WELWYN HATFIELD COUNCIL – DEVELOPMENT CONTROL
DELEGATED REPORT

APPLICATION No:	S6/2007/519/FP
------------------------	-----------------------

The application seeks full planning permission for the removal of the existing covered carport and the building of a two storey side extension, which would have a replacement open car porch on the ground floor to the full depth of the existing property and a new first floor bedroom above and ensuite bathroom. The depth of the extension is approximately 8.3m and approximately 4.8m wide.

Drawing No: 2225-P-01 Revision:

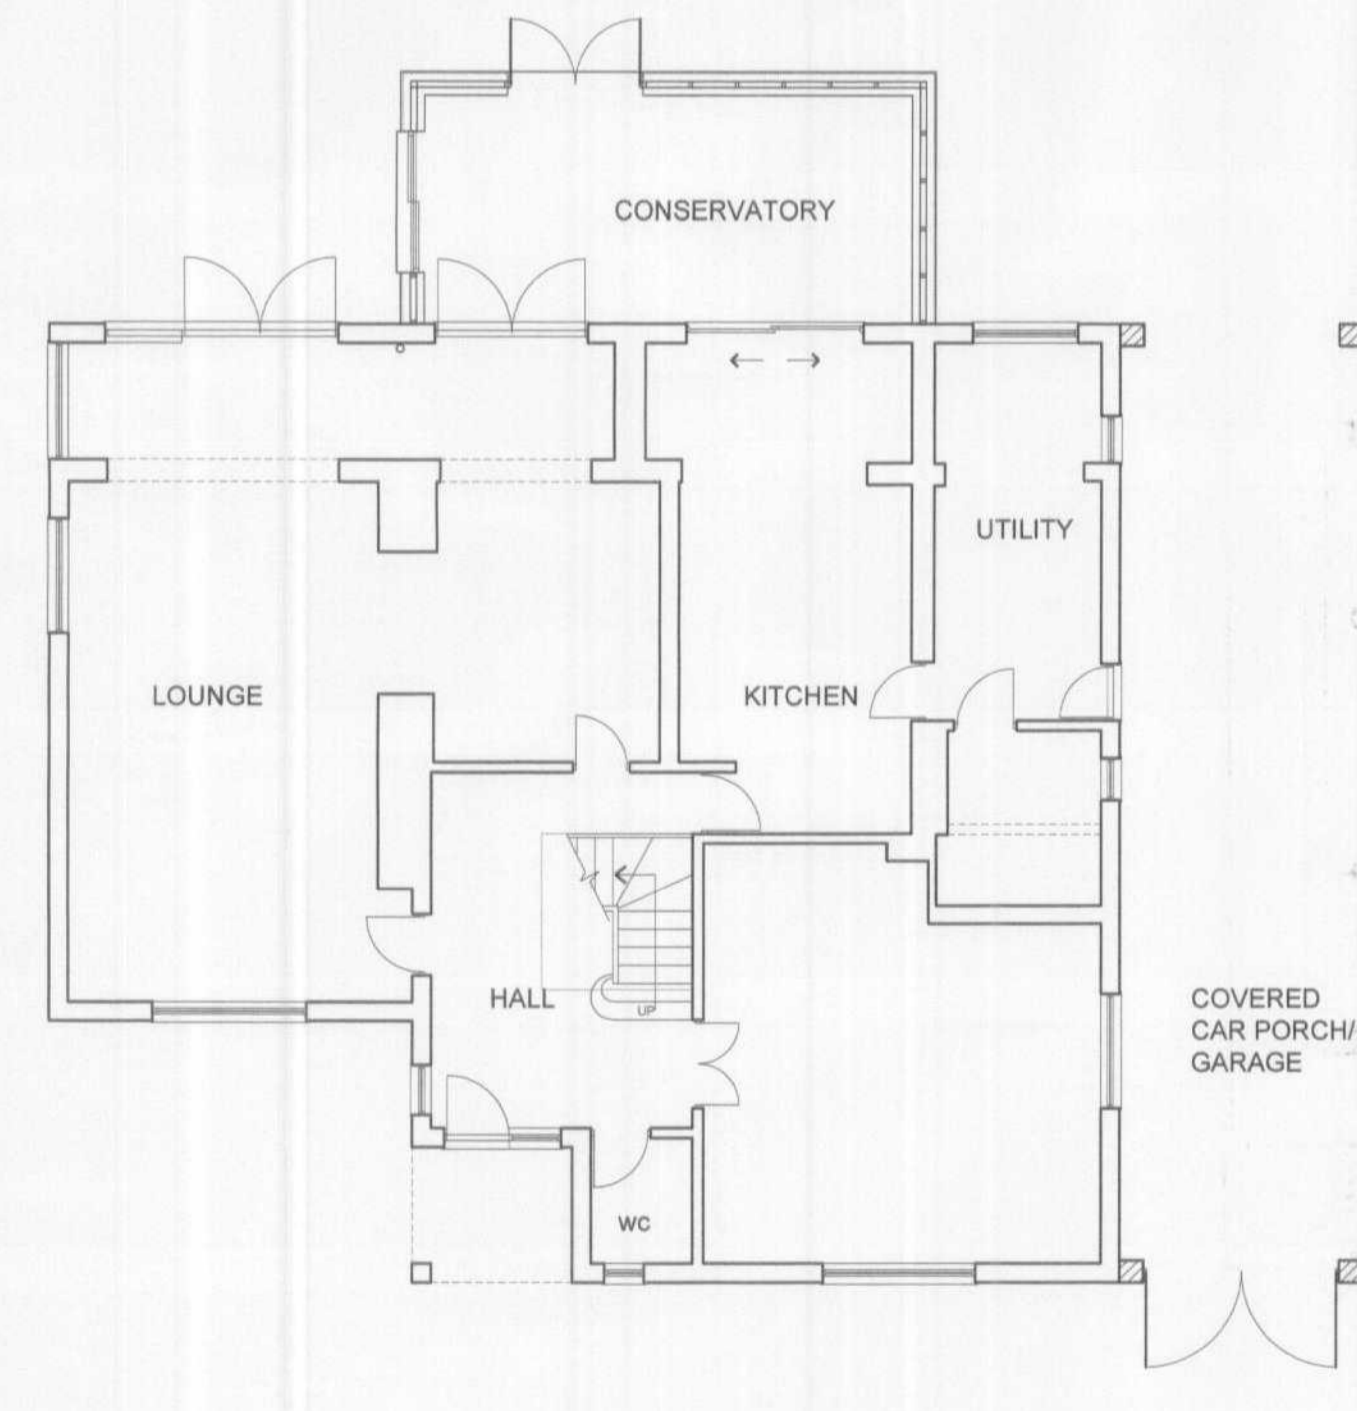
The current proposal would significantly reduce the existing gap to around approximately 0.75m from the common boundary with No.129. It is considered that the proposal will result in a disproportionate increase over and above the size of the

The proposal, as already discussed above would significantly erode the existing space as the extension would be only be approximately 0.75m from the common boundary. The SDG requires as an absolute minimum of 1m and in some cases an even greater distance. In this particular location, the general character of the immediate locality is of spaces larger than 1m, and although there are a few exceptions to this there are examples of much greater distances. The proposed distance therefore falls short of the minimum of 1m and I would suggest that in this location it would not be unreasonable to expect a larger gap to be maintained than the minimum.

It is acknowledged that the proposal would have an impact on the sunlight/daylight to this adjoining window, however, this is no longer the only window serving a bedroom, but is I would suggest a secondary window compared with the rear dormer window. The owner has indicated that the wall could be reinstated to re-create the original layout, however, it is the current situation which is relevant and a material consideration. Furthermore, it is not the purpose of the planning system to preserve sunlight/daylight levels, but to simply ensure that an adequate level is retained, which is considered to be the case on this situation.

The General Permitted development Order does allow under Class C ‘any other alteration to the roof of a dwelling house’. Balconies are normally associated under this part of the GPDO and so can be classified as permitted development. However, case law has shown that the volume of the railings themselves does create additional volume, and when considered with the existing extensions and also the proposals this would be over the 70 cubic metre allowance. I am wary of the fact that under the current review of the GPDO that all balconies may require planning permission. The current legislation requires the LPA to ensure that the amenity of neighbours is safeguarded. The proposal would allow overlooking to both rear gardens of Nos.125 & 129 to a degree that would fail to comply with the requirements of the SDG.

1. The proposed first floor side extension would, by reason of its proximity to the flank boundary with No.129 The Ridgeway and the resultant loss of existing space within the streets scene, result in a form of development of a cramped appearance and over development of the plot width that fails to reflect the established character of the area to the detriment of the appearance of the locality, and would thereby be contrary to policies D1 and D2 of the Welwyn Hatfield District Plan 2005 and Supplementary Design Guidance (Statement of Council Policy).

2. The cumulative effect of the proposed development would, when considered in relation to previous extensions to the dwellinghouse, result in a disproportionate impact in terms of the size, bulk and prominence of the existing buildings on the site in this Green Belt location and so would diminish the openness of this part of the Green Belt to the detriment of the rural character of the area contrary to the requirements of Policy RA3 of the Welwyn Hatfield District Plan 2005. There are no very special circumstances which have been advanced to justify a departure from the Green Belt Policies of restraint.

3. The proposed railings to the rear first floor would create an outside balcony area which would, due to their elevated position and close proximity to the side boundaries with Nos.129 & 125 The Ridgeway, result in an unacceptable loss of privacy to these adjoining neighbours contrary to the requirements of Policy D1 of the Welwyn Hatfield District Plan 2005 and the accompanying Supplementary Design Guidance (Statement of Council Policy).
